THE LEGACY AT SUNCADIA SUNCADIA - PHASE 1 DIVISION 6

A PORTION OF SECTIONS 19 AND 20, TOWNSHIP 20 NORTH, RANGE 15 EAST, W.M.
KITITAS COUNTY, WASHINGTON
ASSESSOR PARCEL NUMBER 21930 AND PTN 11864

DATE: 2017-04-10 JOB NO. 99B-753-016-0002
DRAWN BY: C.A.F./R.F.G. SHEET 1 OF 6

DATE: 2017-04-10 JOB NO. 998-753-016-0002
 DRAWN BY: C.A.F./R.F.G. SHEET 1 OF 6

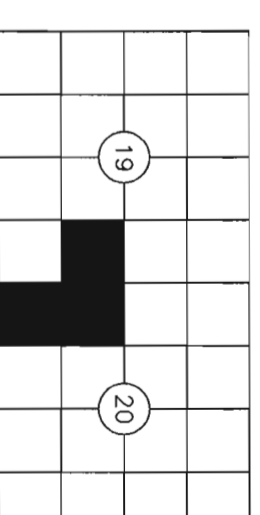
*FOR OUR CODE -
- OUR CODE SUCKS -
UTILIZE STANDARD
STATEMENT PER
RCW 58.09.080*

*CINDY FLOOD
@ESM NOT CLOUTIER'S -
TO PROVIDE*
